From: Julia Davies [REDACTED]
Sent: 17 April 2020 11:47
To: Zac Denton <Zac.Denton@arun.gov.uk>
Subject: 27 Shrubbs Drive, Middleton-on-Sea (M/19/20/HH)

Block Plan
Scale 1 : 5 0 0

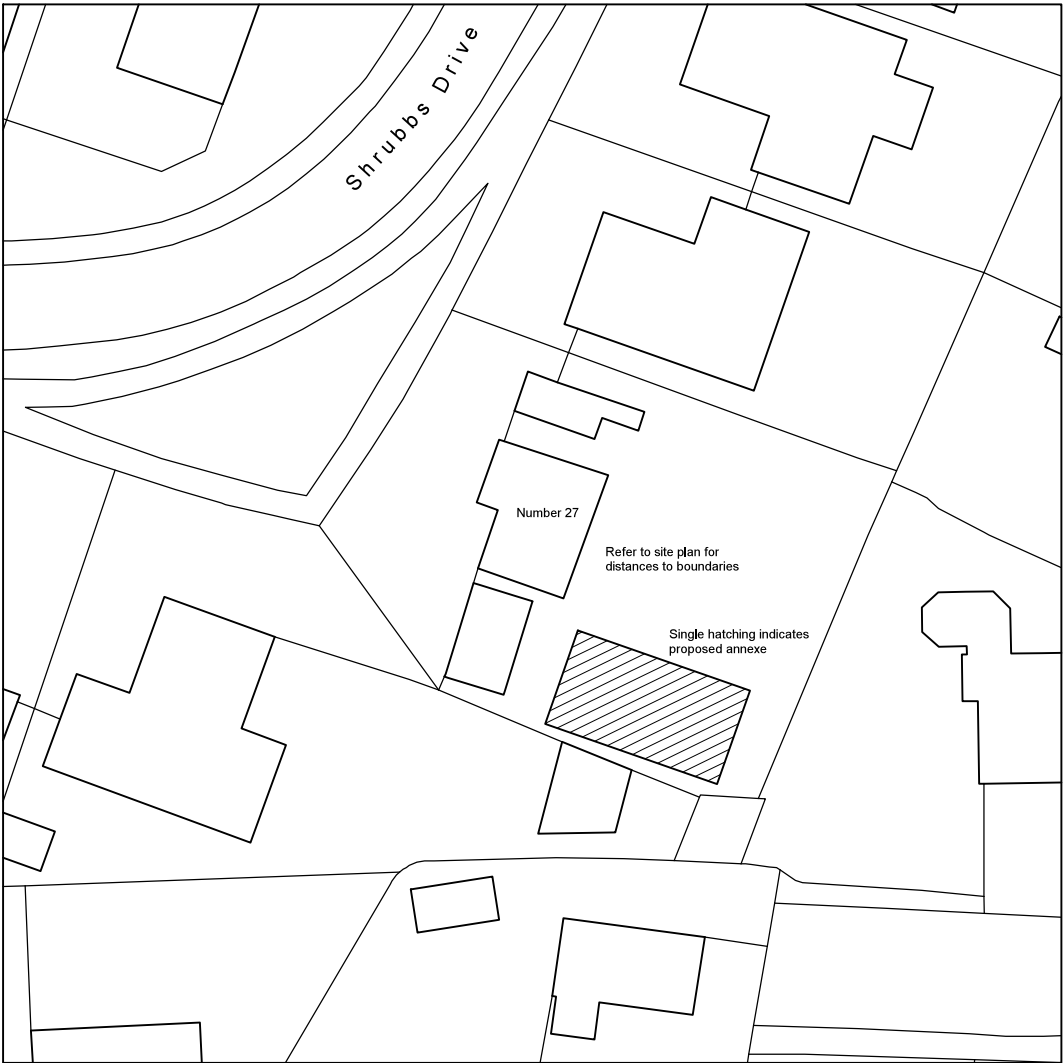
Even with the addition of the annexe, the remaining amenity space is still greater than that of the neighbouring properties as can be seen on the block plan.

Site Plan

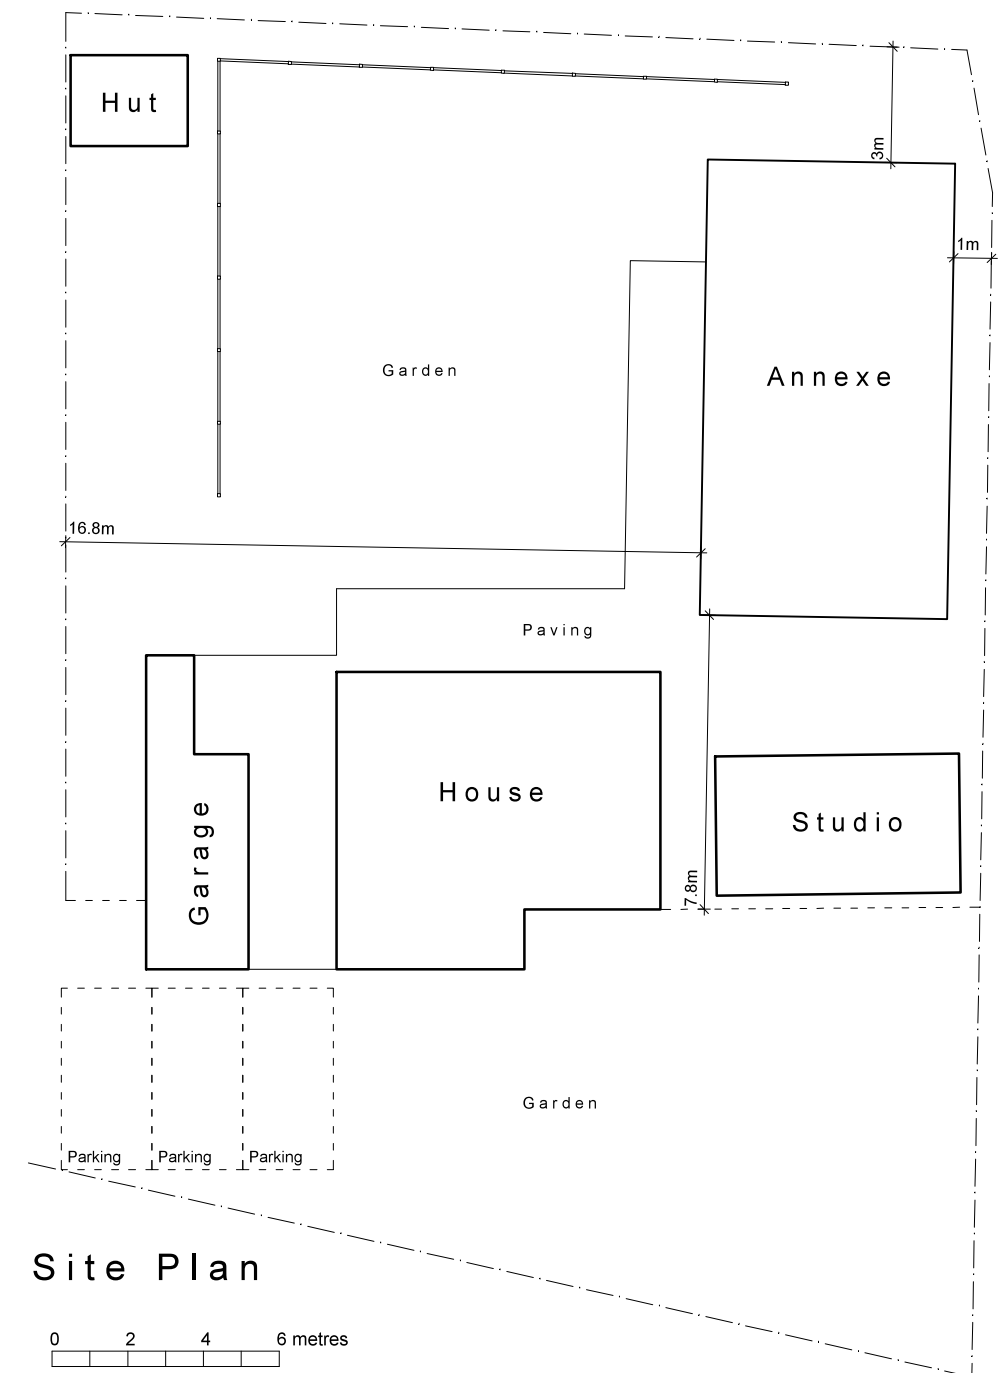
Whilst I appreciate that the pre-application drawings did not show the building in context, our site plan shows that the building does sit comfortably on the site, with adequate distances to the boundaries and ample amenity space.
